May 20, 1997

RE: REVISED DRAINAGE PLAN FOR VANGUARD PRINTING (J14-D21) REVISION
DATED 5/13/97

Based on the information provided on your May 14, 1997 resubmittal, listed are some concerns that will need to be addressed prior to final approval:

Van Guard Printing Co. DRAINAGE AND GRADING PLAN

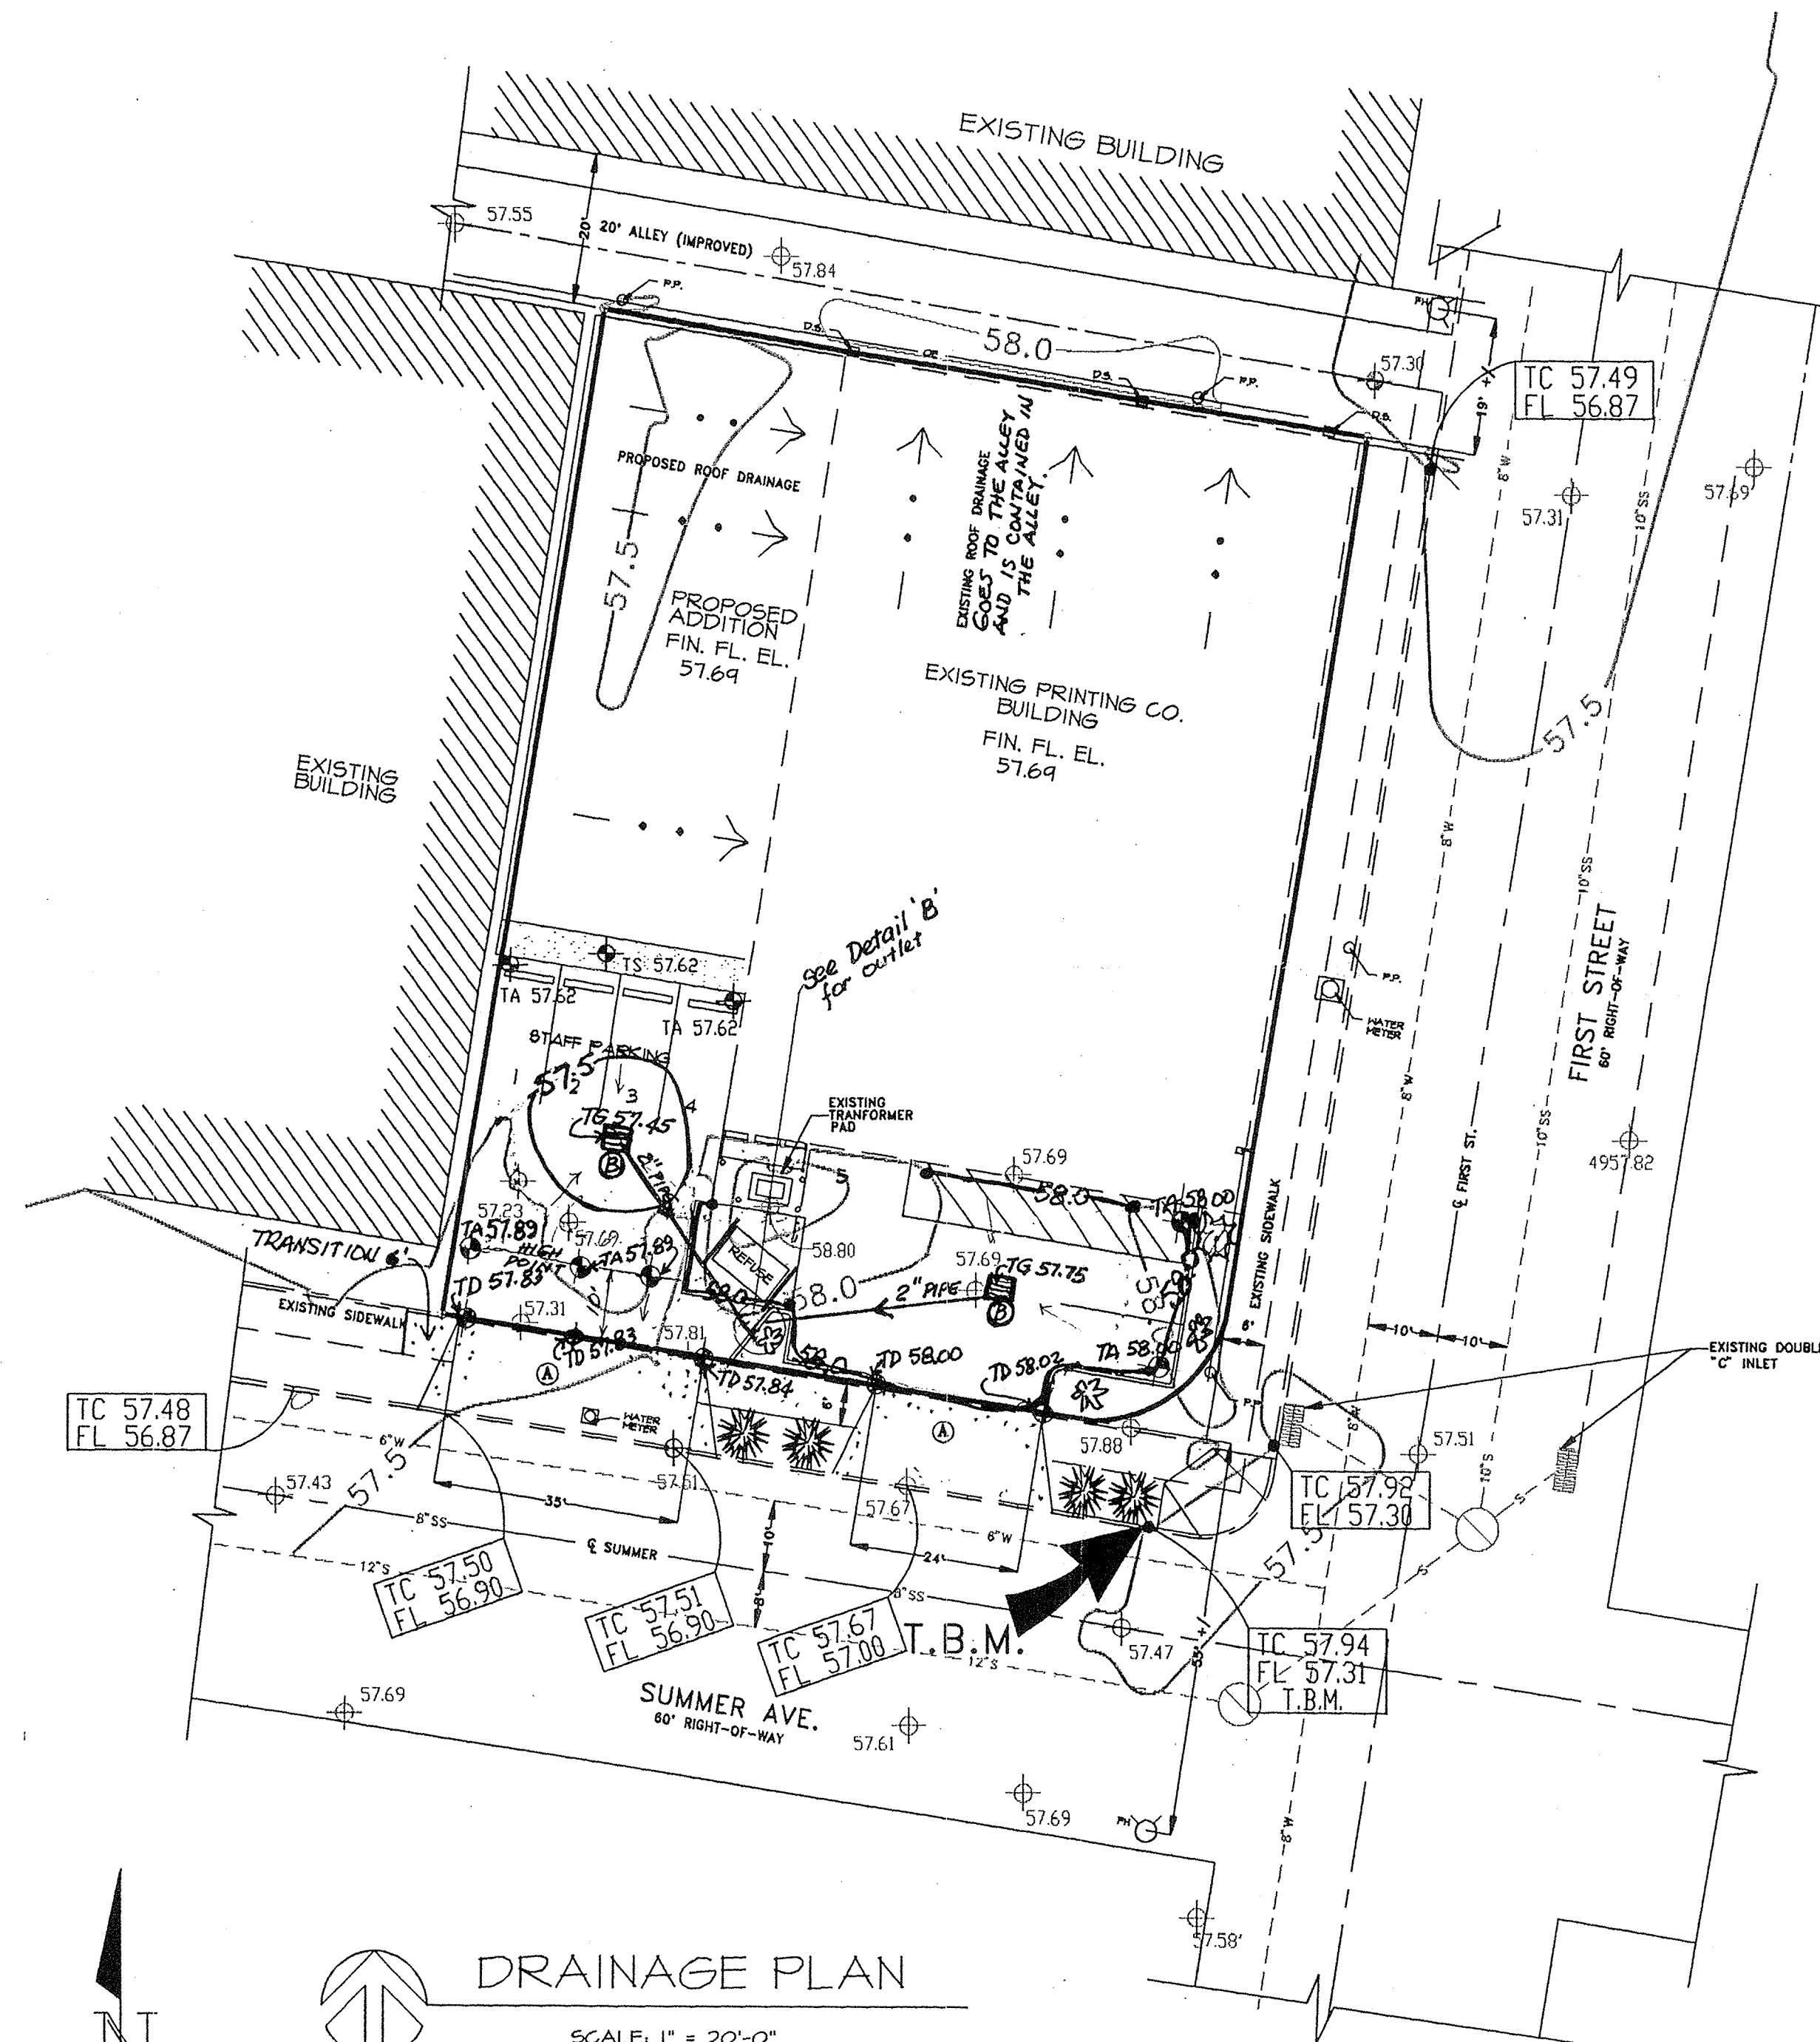
1. Site Plan does not match the drainage plan. Please address
2. Your proposed inlets will need to be drained out towards the gutter of the street. I recommend that you investigate the possibility of draining the inlets to the back of the existing double "C" inlet on First Street.
3. Please include the invert elevations for the pipes and inlets.
3. Traffic Engineering has reduced the length of one of the drivepads, please coordinate with the Architect.
4. If you decide to drain the inlets to the existing double "C" please include the six notes and sign-off block from the SO19 format.
